Our Ref: F2019/00109

Application No: SSD 9606

**RE: Randwick City Council Submission on the State Significant Development
Application: Building D14, University of New South Wales Kensington Campus
(SSD 9606)**

Ground Plan
Date
12.04.19
Project No. 18026
Drawing No. ADDA20000
Revision 05

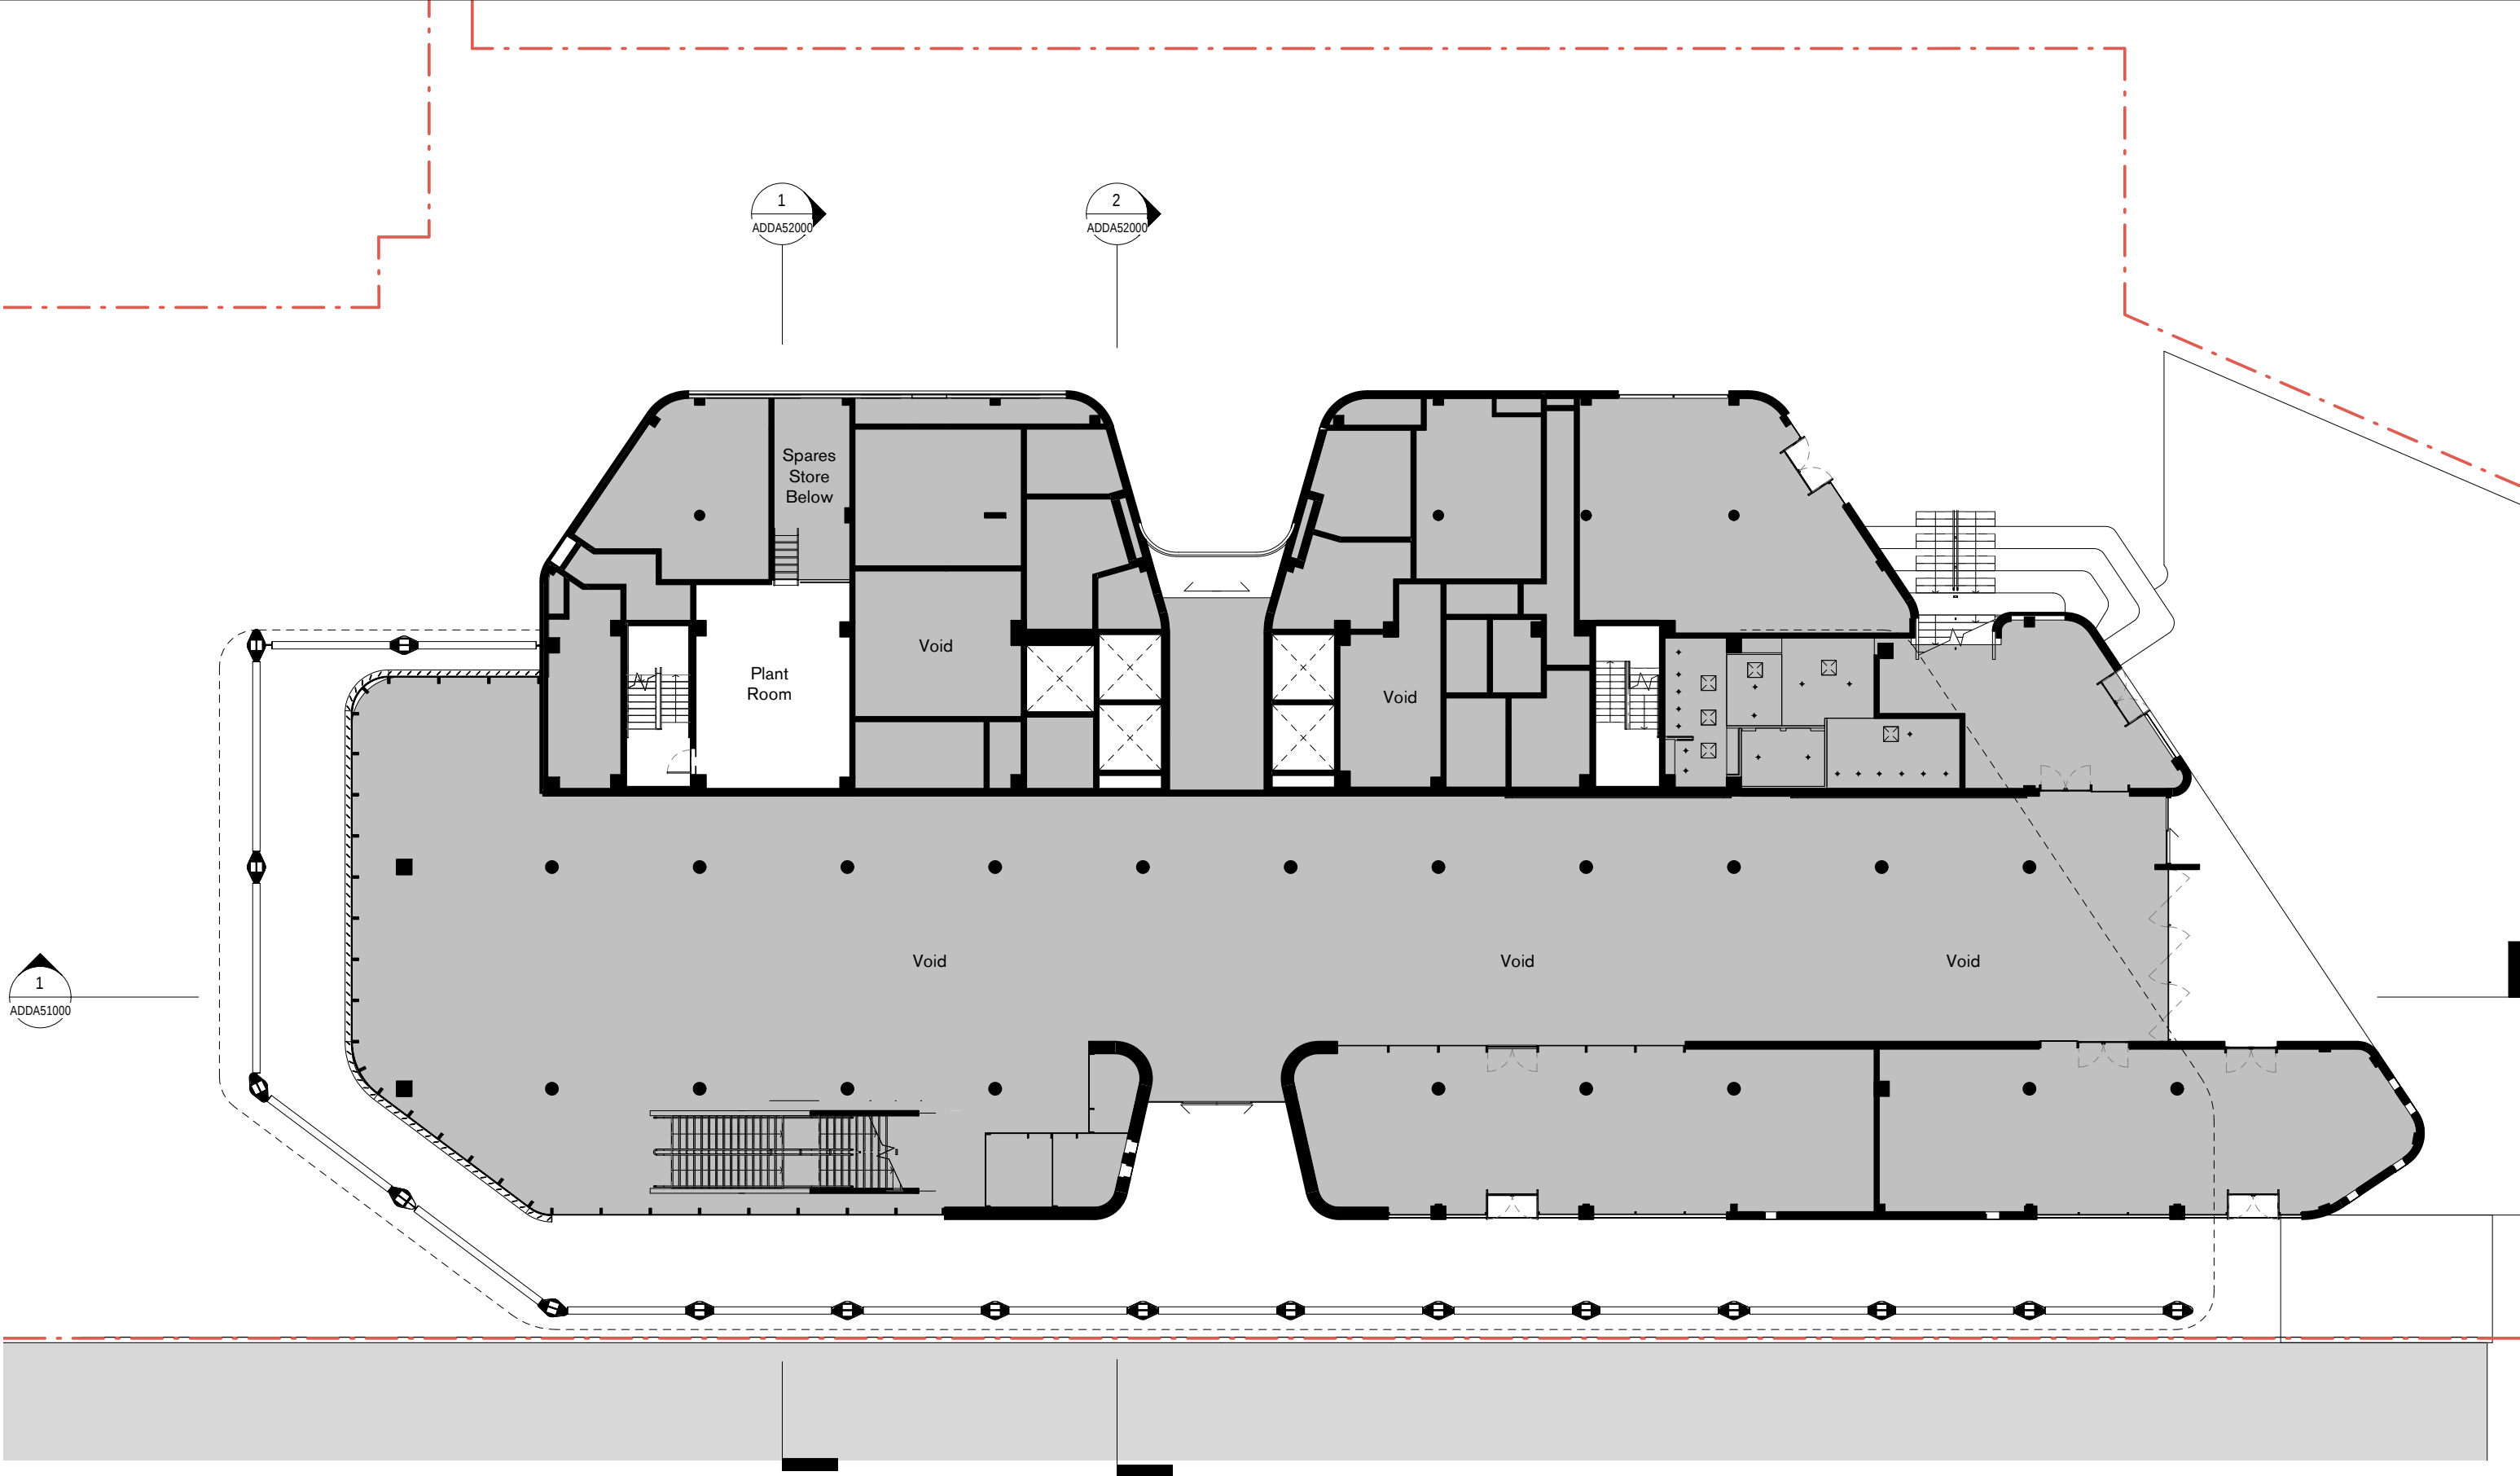
Council requests that the scale of the development is reduced on the eastern and south-eastern portion of the proposed development. Architectural drawings ADDA20000, ADDA20M00 and ADDA20100 indicate that this section will include retail and student led space on ground floor, void space, and an external balcony on level 1. It is considered that the bulk and scale of this section of the proposed development is unnecessary and excessive. Justification is given in the Environmental Impact Statement (EIS) that the

Council is of the view that the deletion of the lower two storey ground plane element and a revised design of this section of the development will result in an improved built form and interface with the heritage conservation area and White House heritage item.
